OXFORDSHIRE COUNTY COUNCIL'S RESPONSE TO CONSULTATION ON THE FOLLOWING DEVELOPMENT PROPOSAL

Application no: 21/04202/F

Proposal: Redevelopment for 80 retirement living apartments including communal facilities, access, car parking and landscaping.

Location: Former Buzz Bingo, Bolton Road, Banbury,

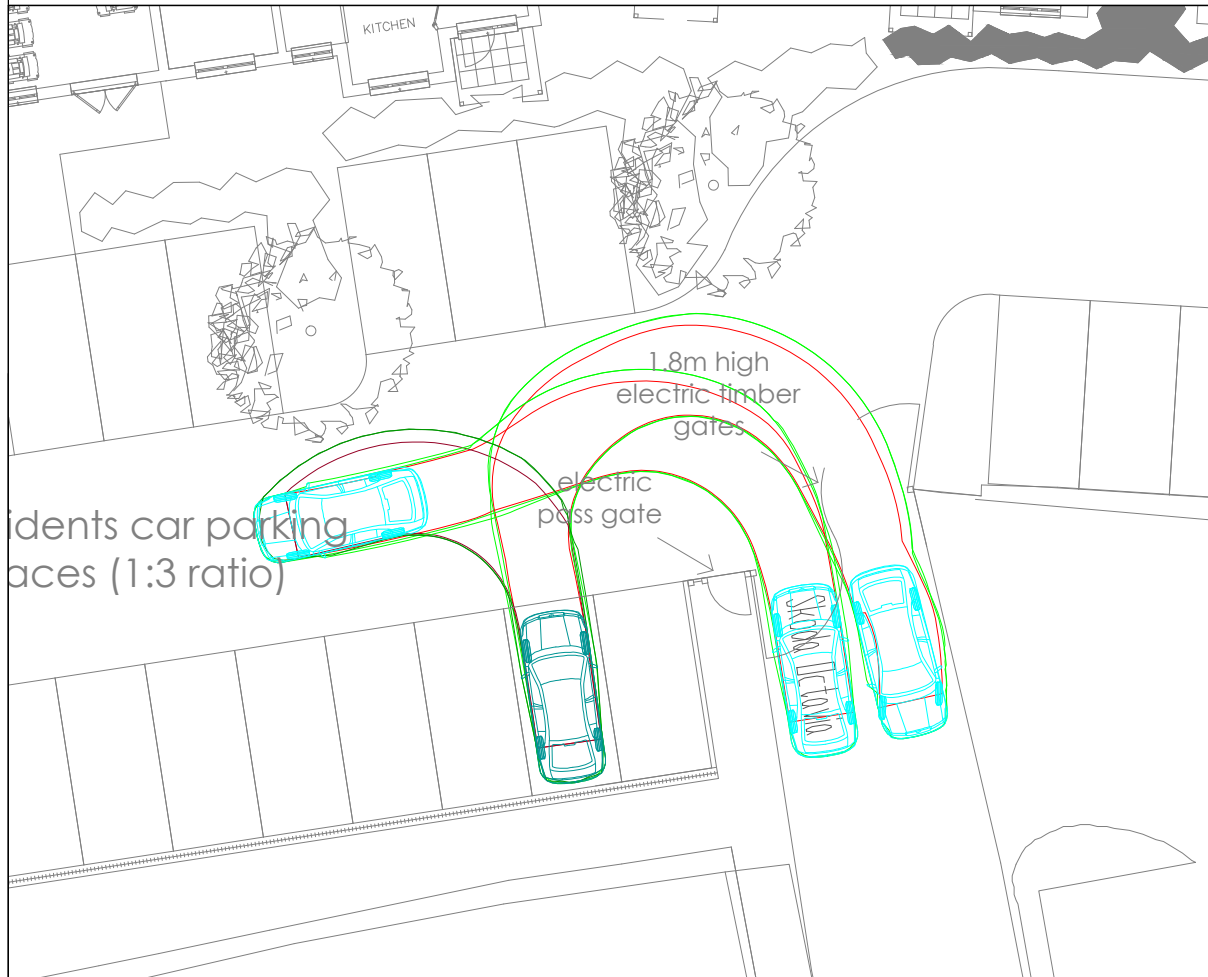
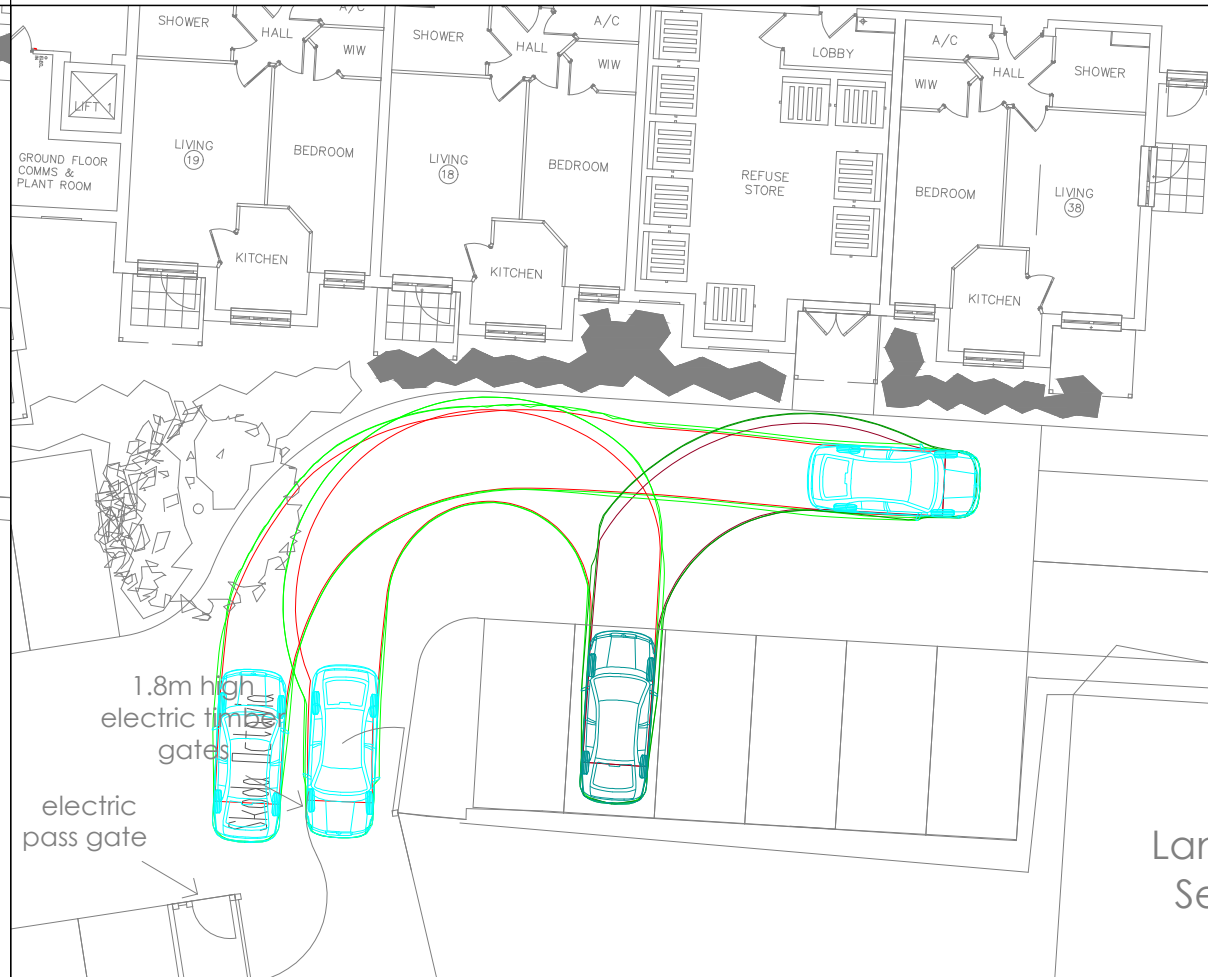
Regarding the vehicle swept paths drawings, the manoeuvres would be tight and just manageable within the parking area. We acknowledge receipt of the updated site plan ref no. PA01 C. which includes a hard standing in front of the Refuse store to accommodate car parking manoeuvres. That said, the revised drawing superimposed with the swept manoeuvres of Refuse vehicles to and from the designated collection point would be needed.
